**Application for a non-material amendment following a grant of planning permission,
Town and Country Planning Act 1990**

**Non material amendment to previous permission 2020/90417 for erection of single
storey extension**

1, Rose Mount, Birkby, Huddersfield, HD2 2BU

Application Number: 2021/91567

Proposed Ground Floor & Site Plan

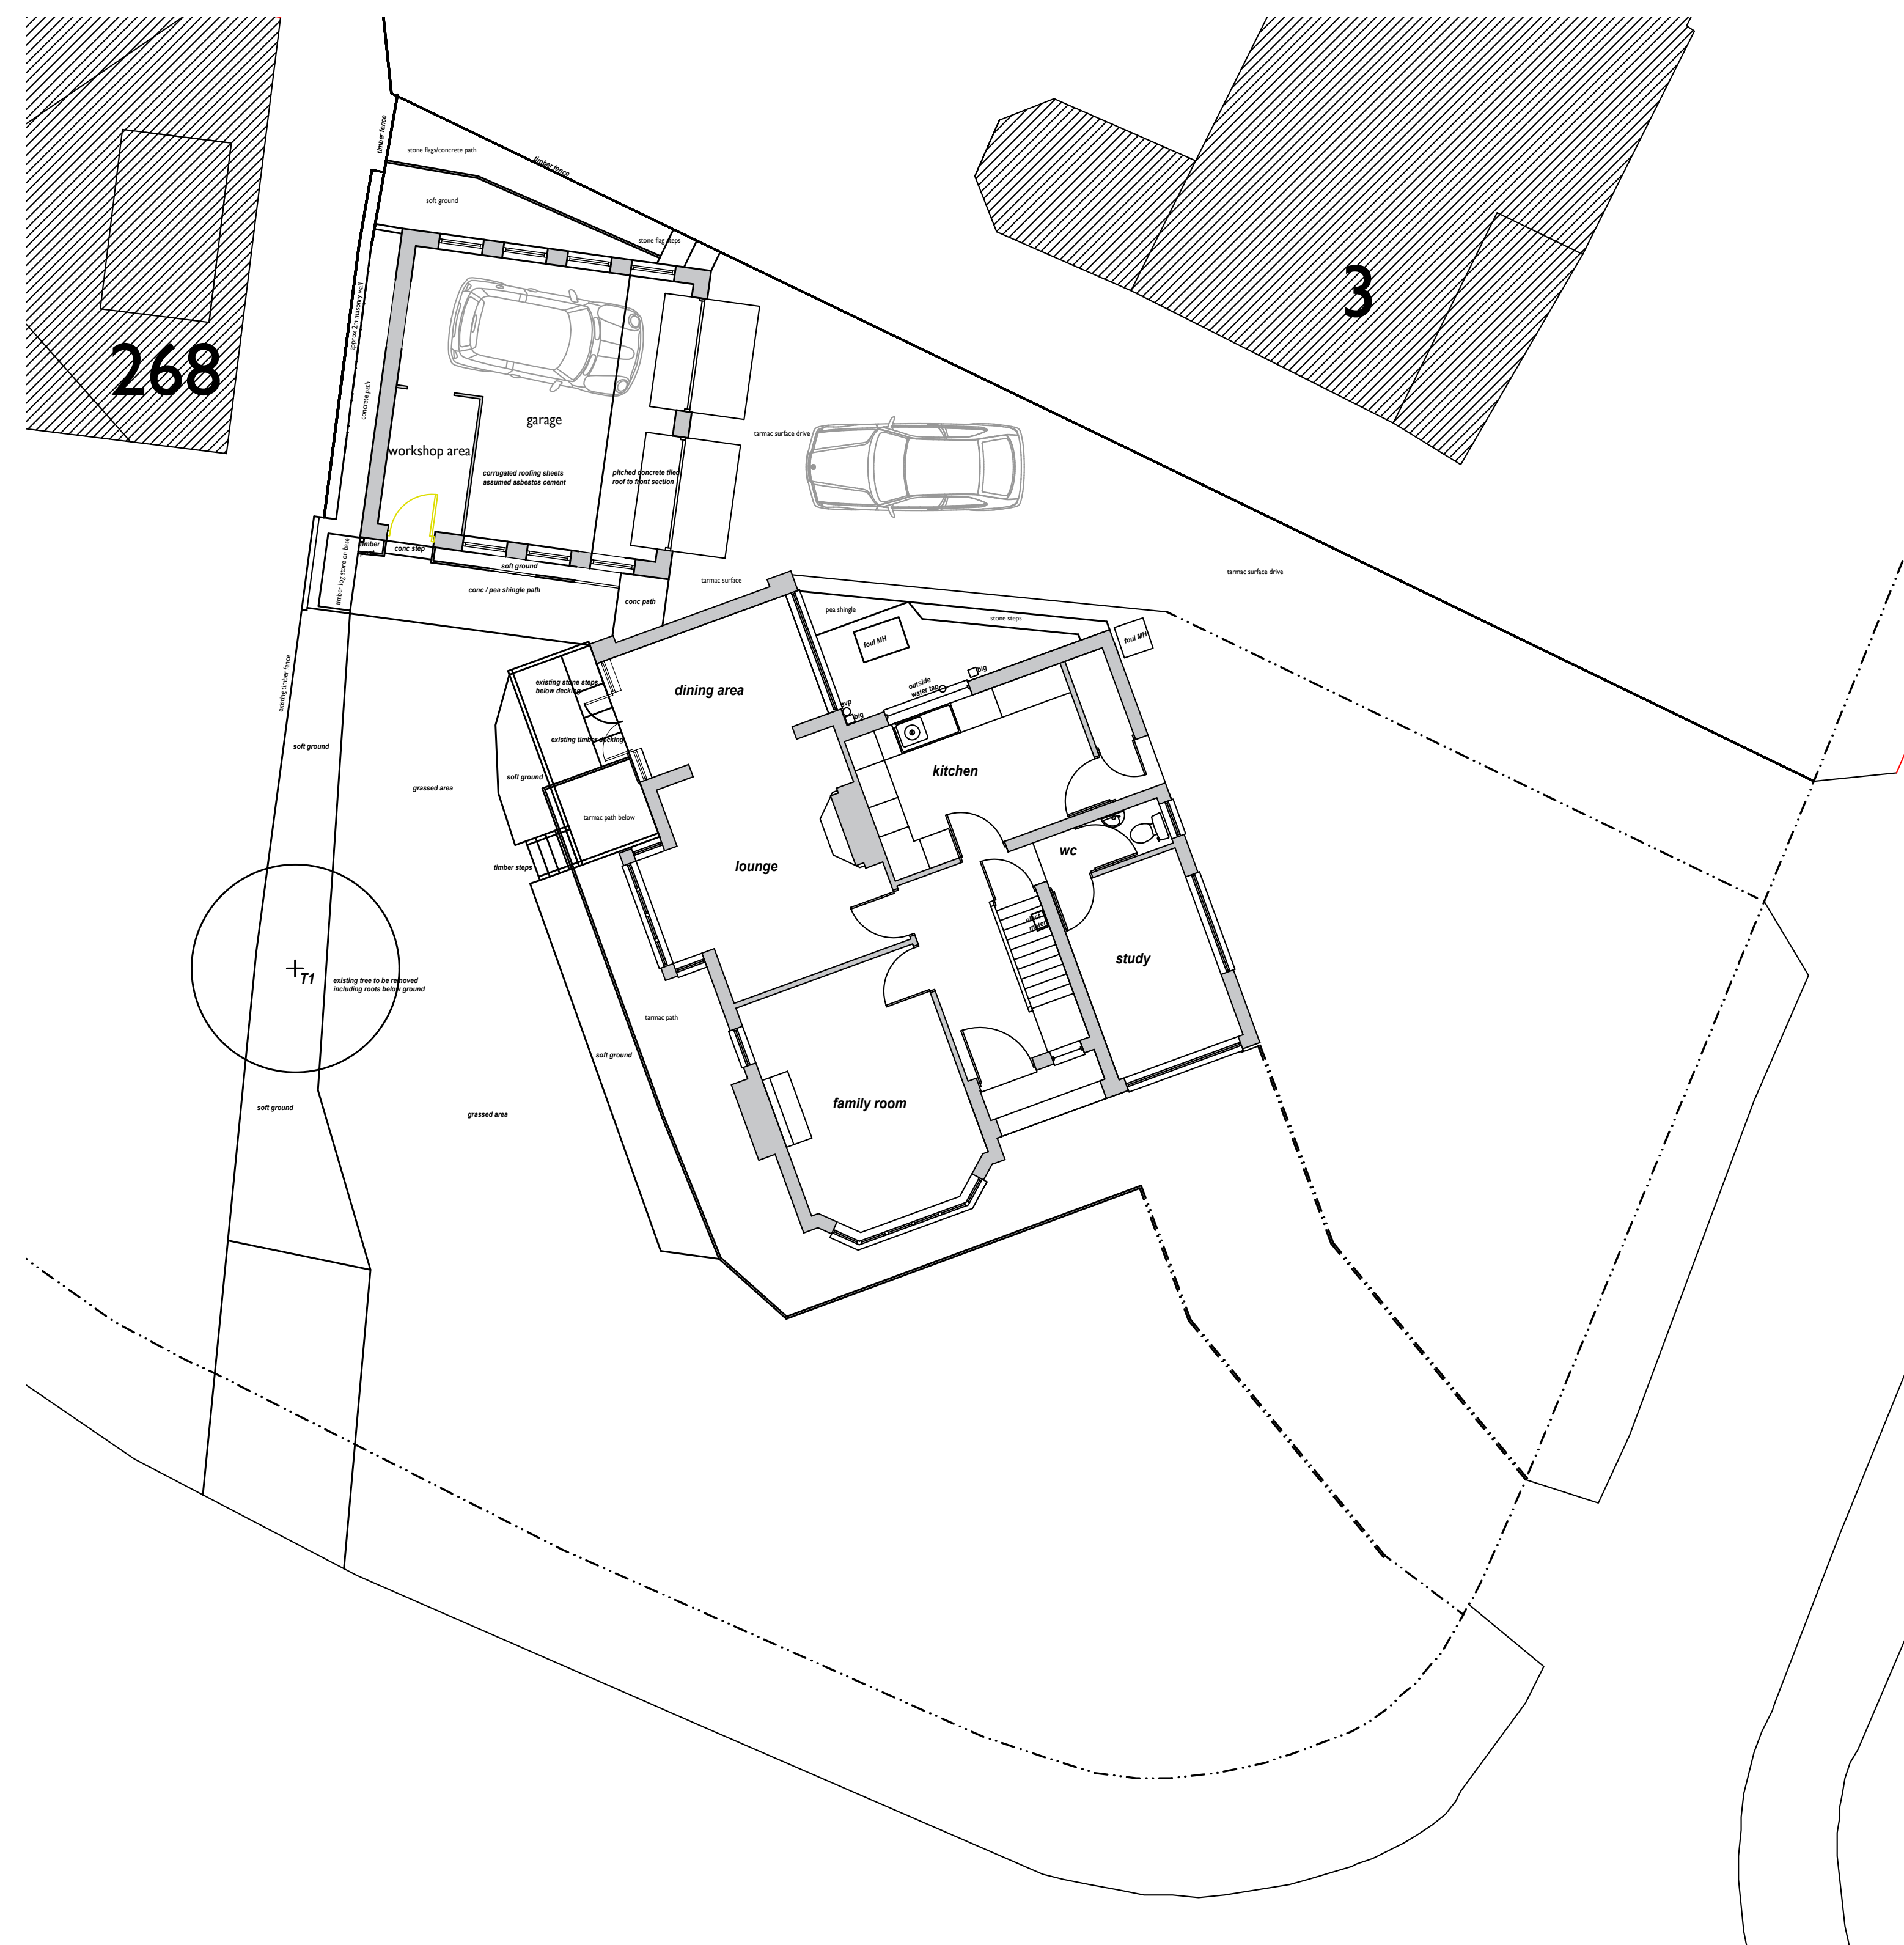
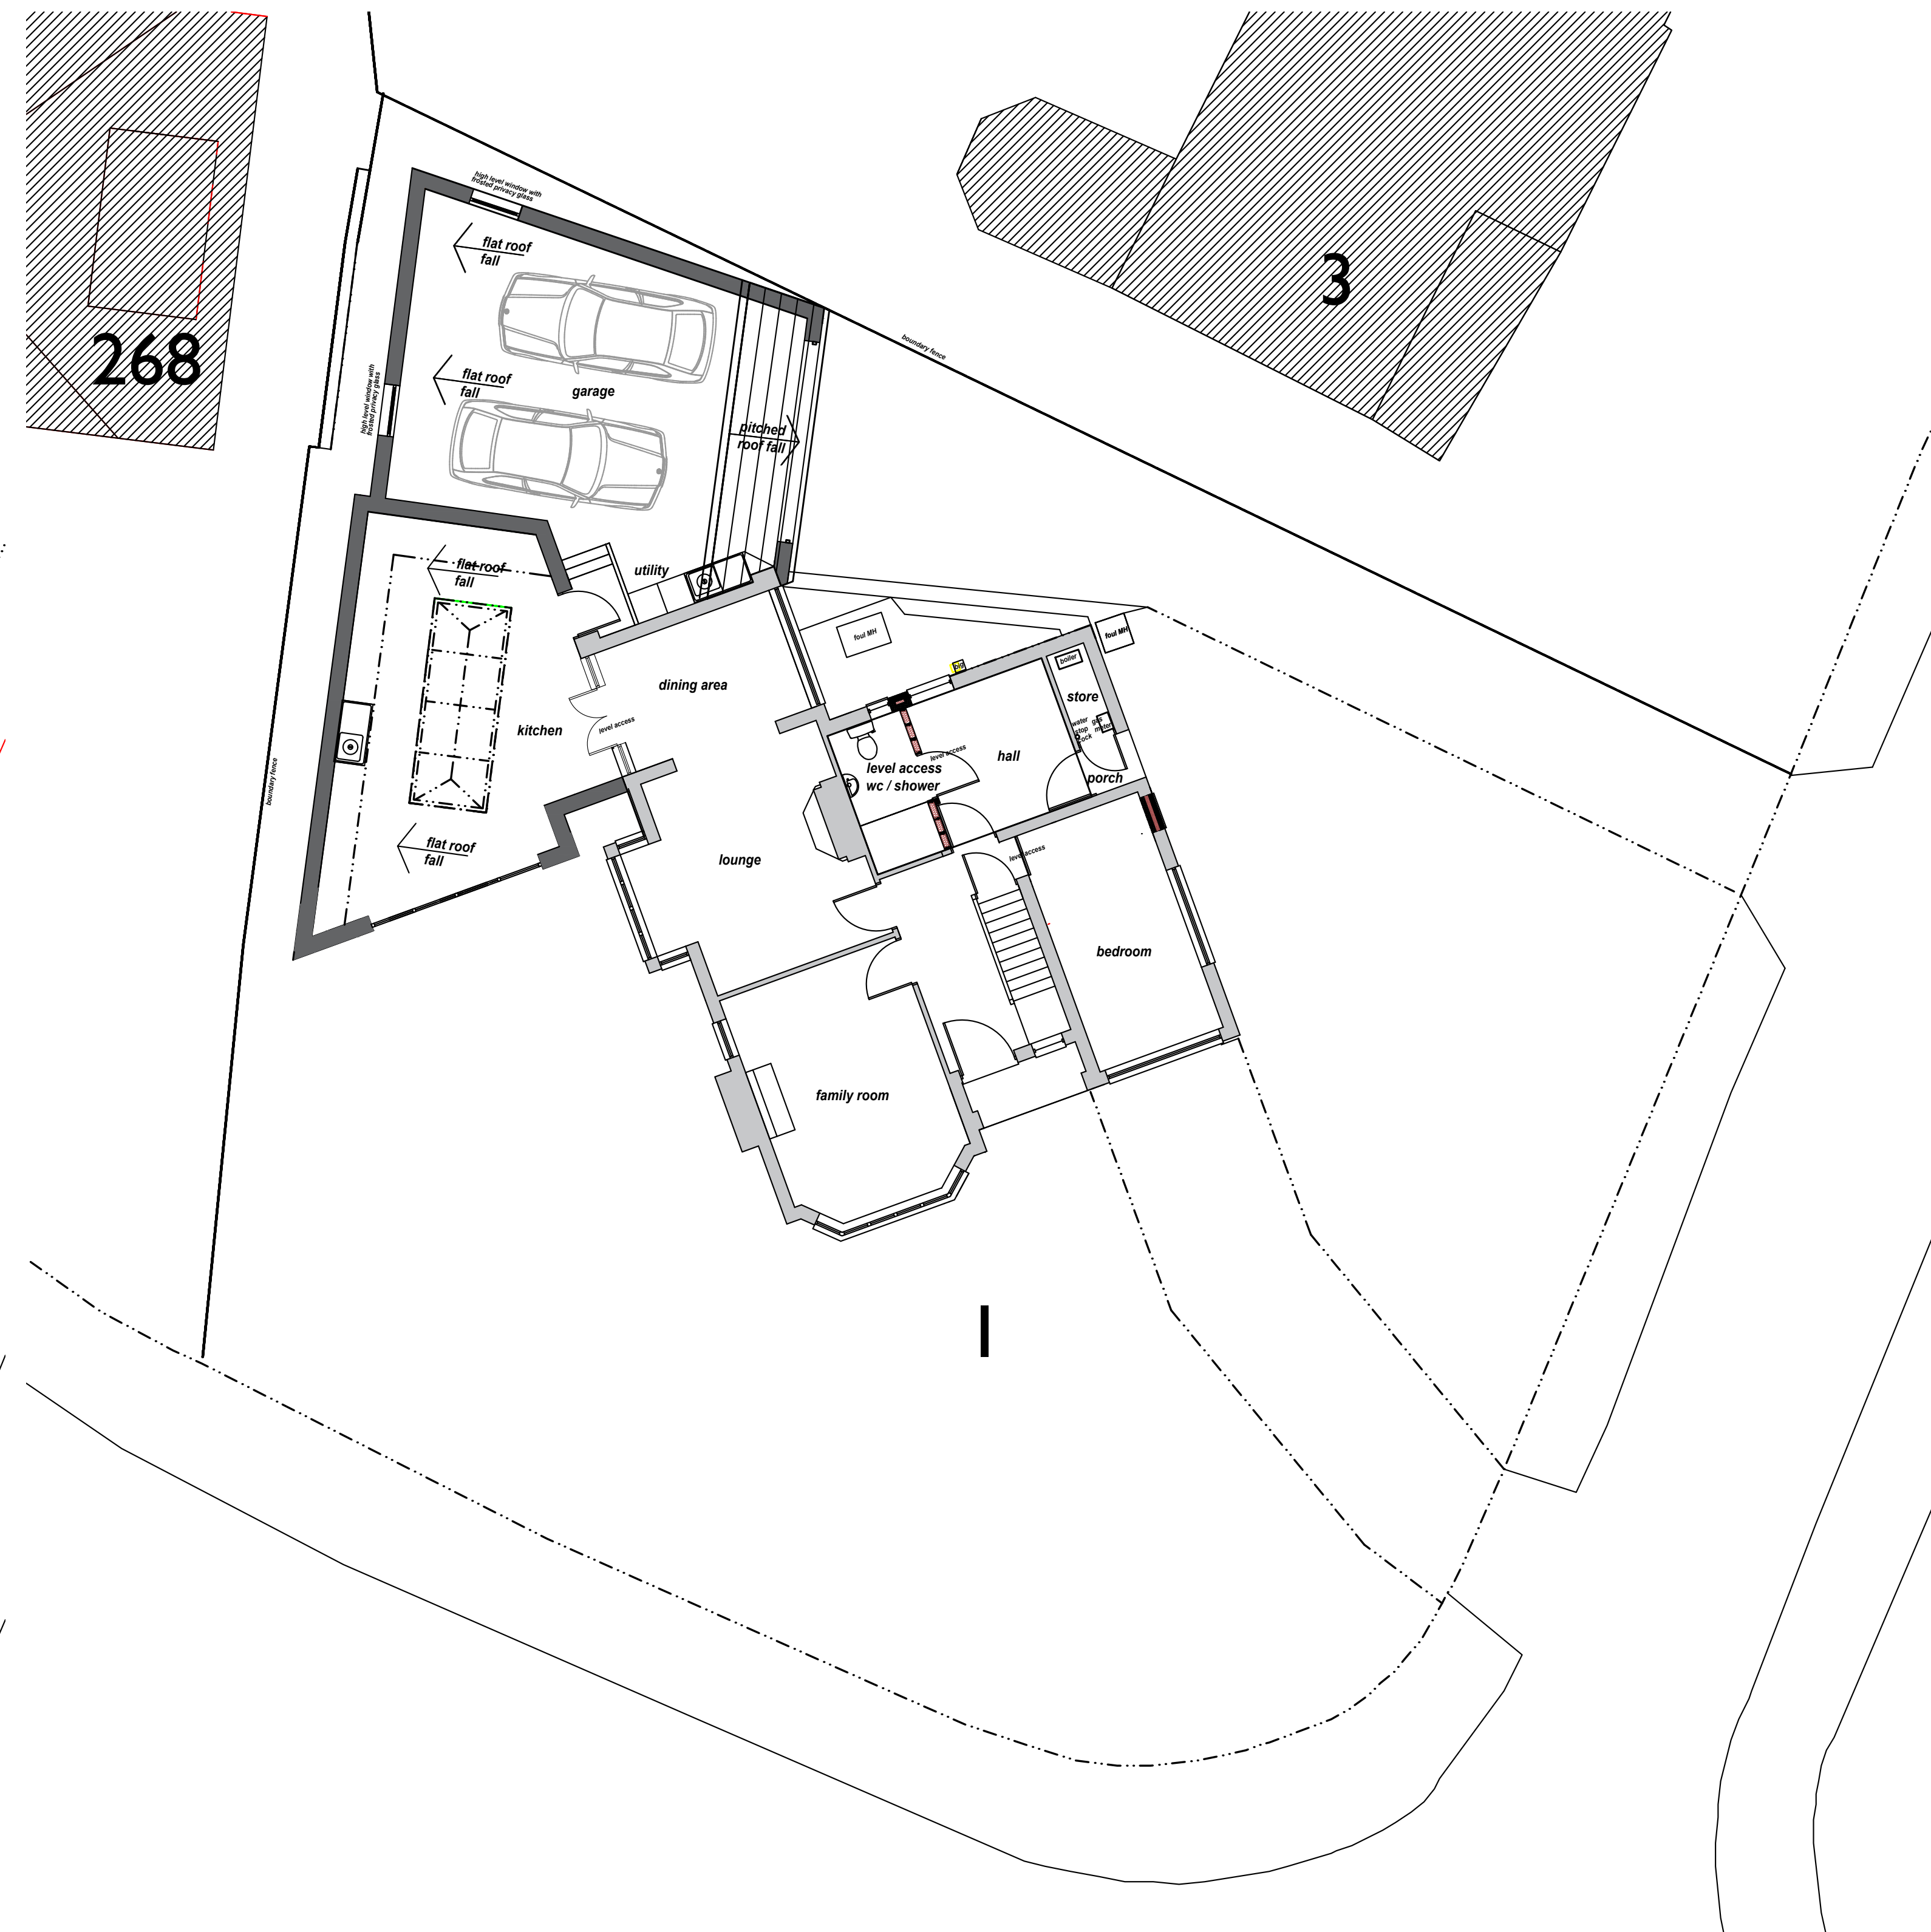
The amendment sought is for a longer roof lantern within the kitchen, a small set back to the rear wall of the garage and also a small pitch to the front of the garage roof as shown on drawing numbers Revision 01 Existing and Proposed Elevations and Revision 01 Existing and proposed Floor Plans.

I confirm that the alterations are acceptable and may be considered as a non-material amendment to the approved drawings. It should be noted that this letter relates only to the non-material amendment sought and it is not a re-issue of the original planning permission. The two documents should be read together and as such, all conditions imposed on the original granting of planning permission apply to the proposal as now amended. A copy of this letter and the amended plans will be retained on the public record of approved documents.
